ATTACHMENT C

Comments on Cumulative Impact Assessment, Subsidence Assessment, Surface to Seam Fracturing Assessment, Geological Structures Assessment, Impact on Coastal Upland Swamps

Dendrobium Mine Extension Project EIS (SSI-33143123)

South32 Illawarra Coal Geological Structures Review Area 5 FAULT LOCATIONS 2020 SEISMIC INTERPRETATION	
PSM3021-012R	Drawing 2

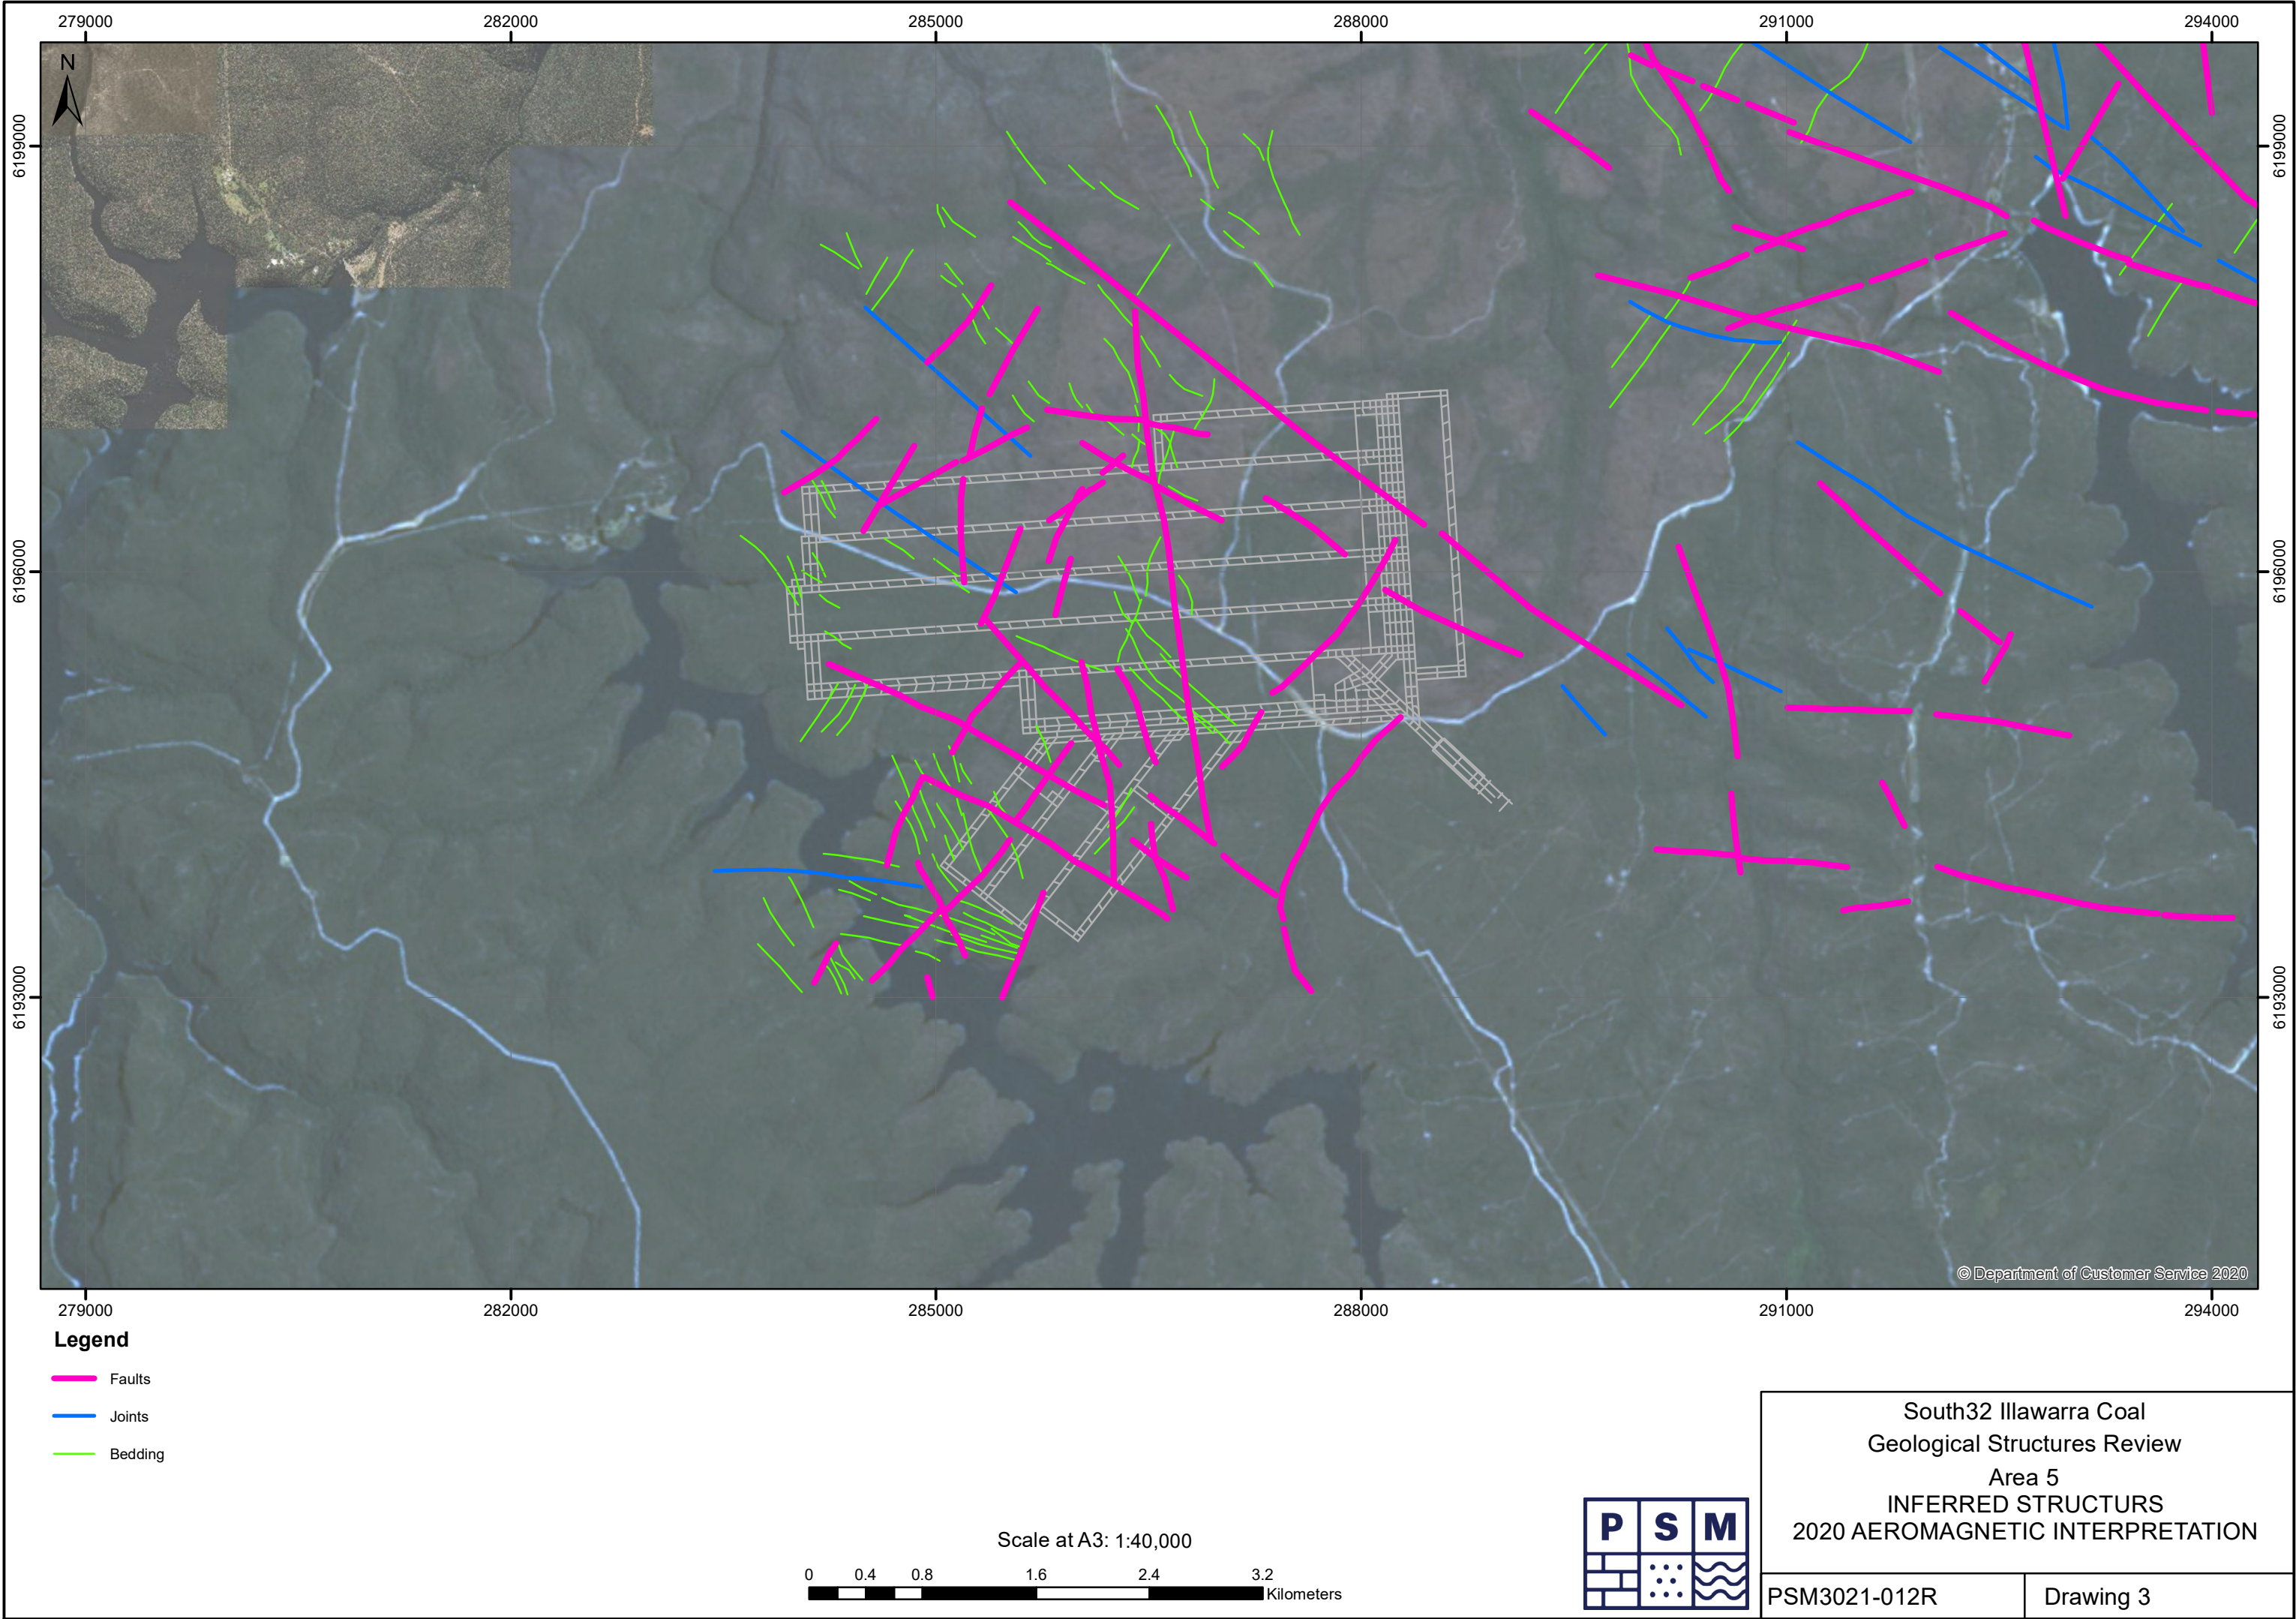
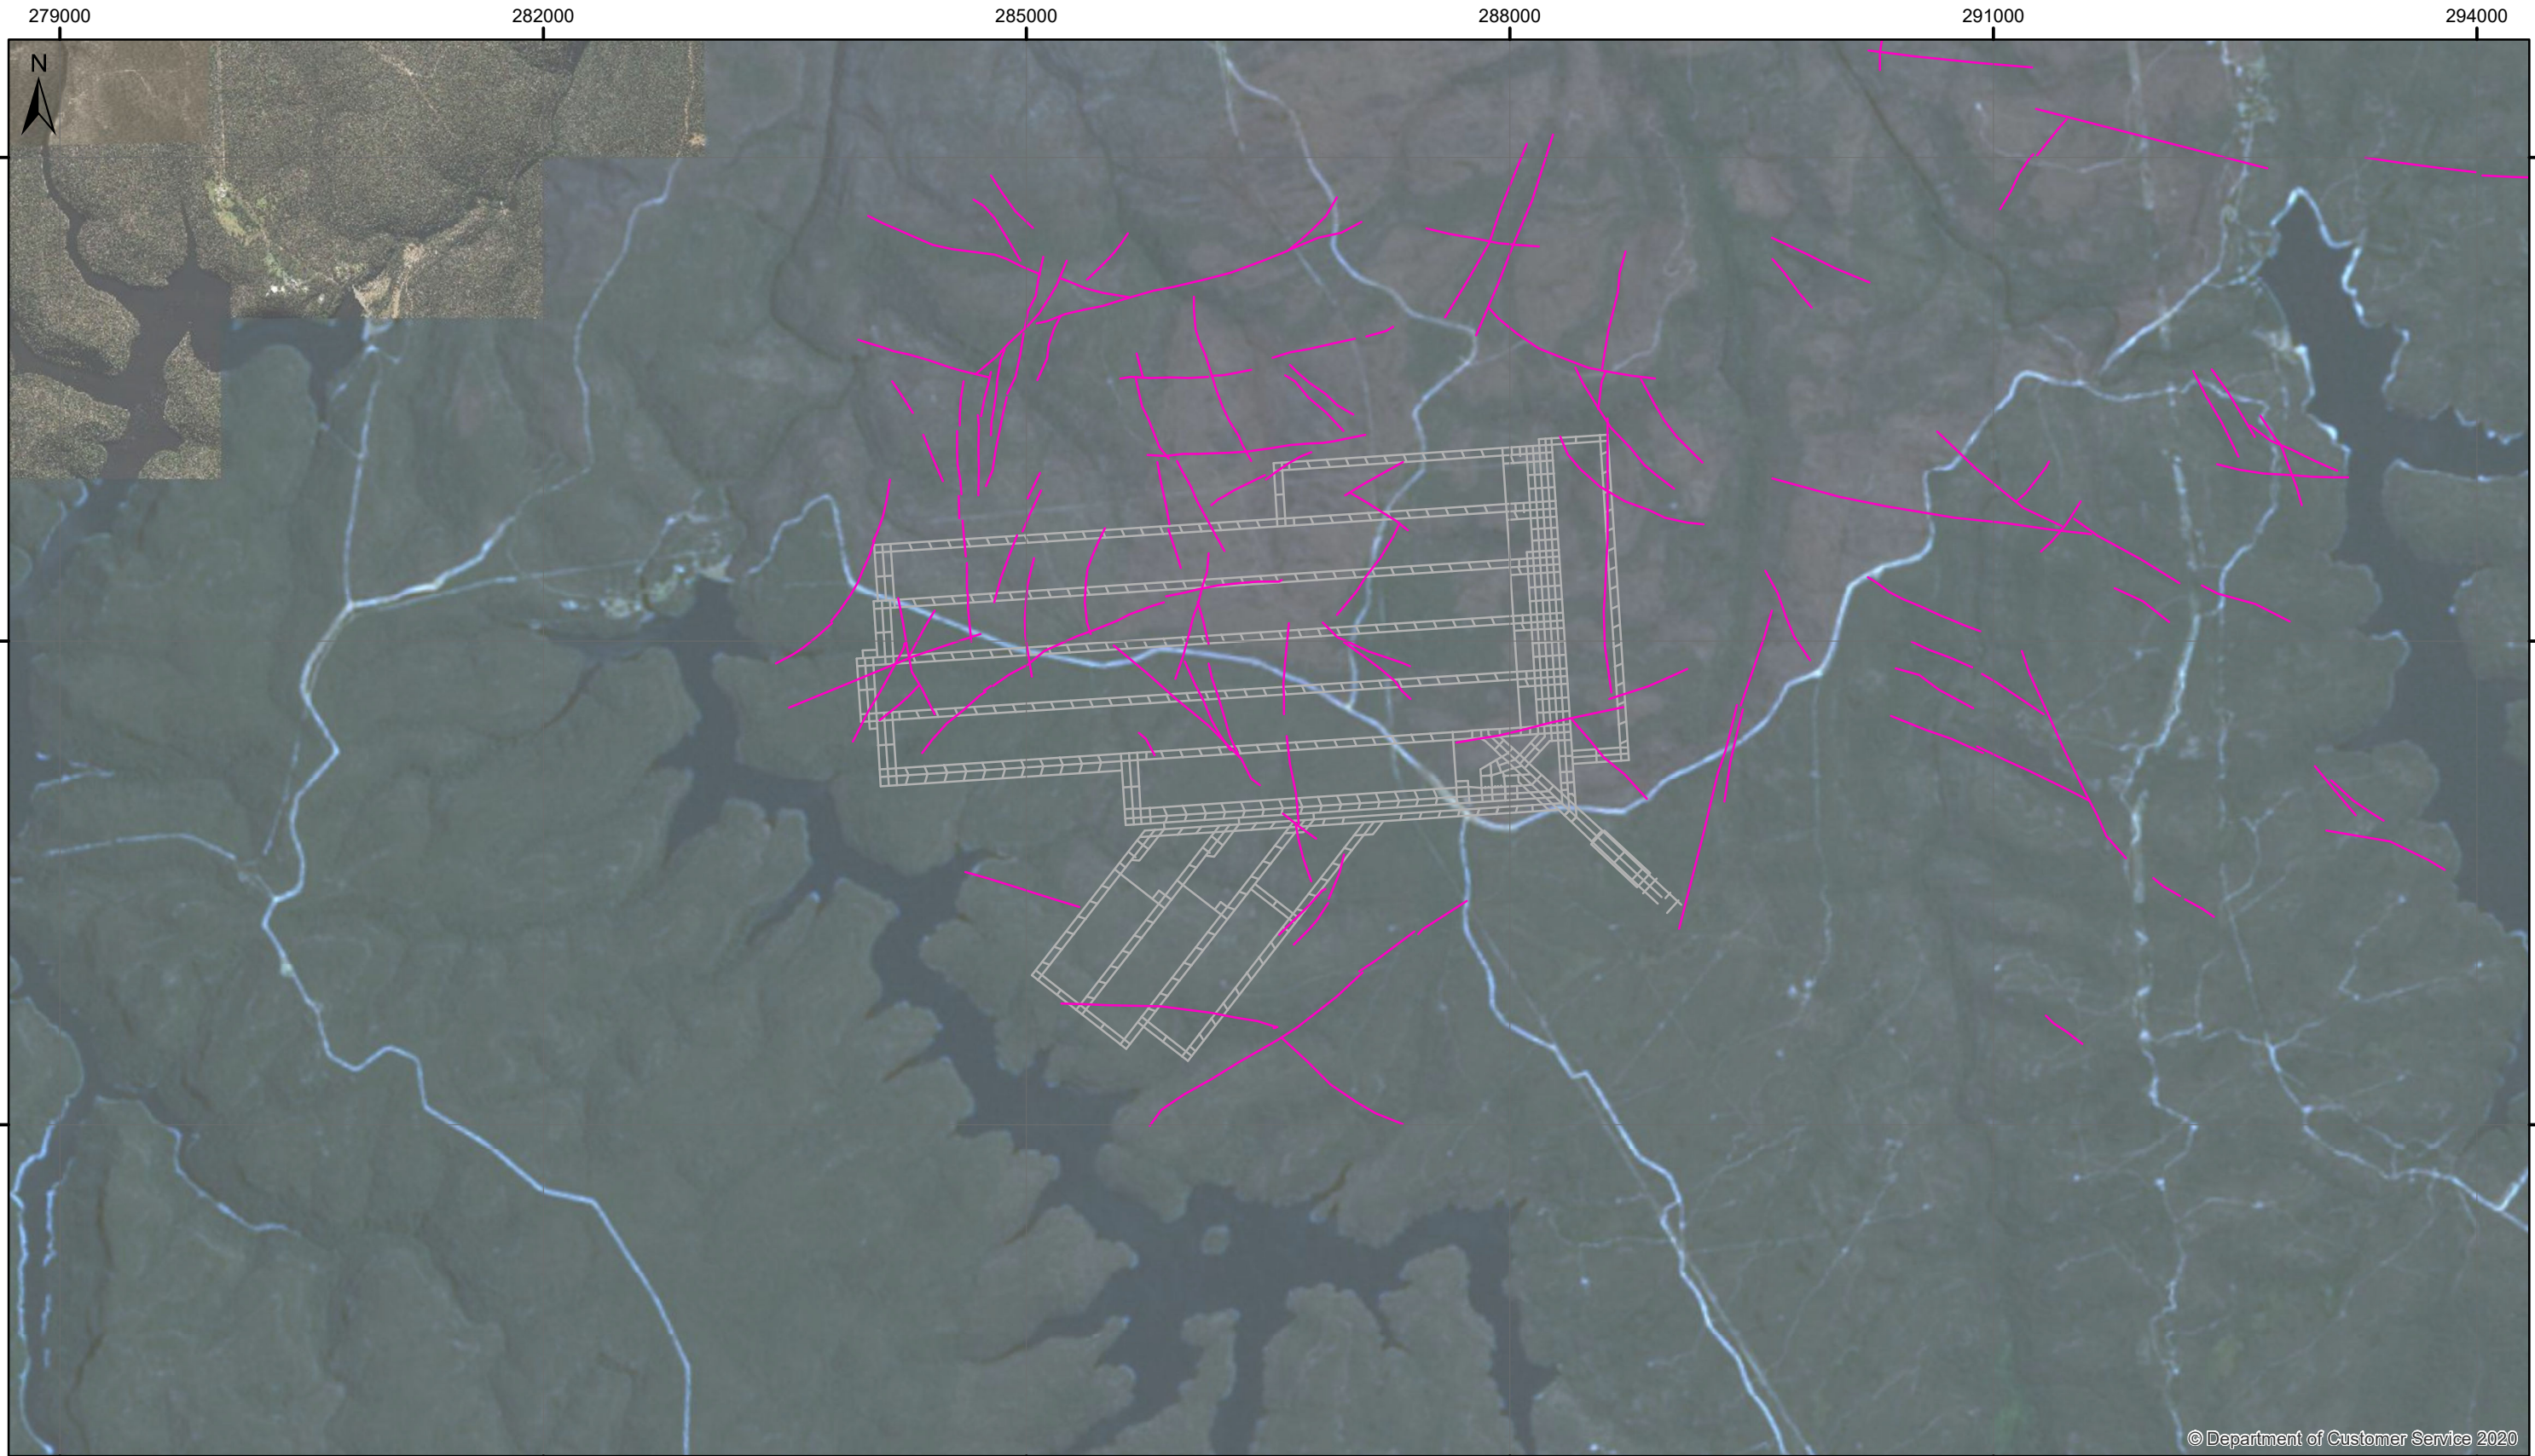
- Needs to improve the assessment of the potential for faults, lineaments and other geological structures to interact with subsidence, potentially leading to even greater fracturing and drainage in streams and swamps;

- The issue of surface to seam connective fracturing and interaction of subsidence with geological structures be referred to the Mining Expert Panel for further independent expert assessment.
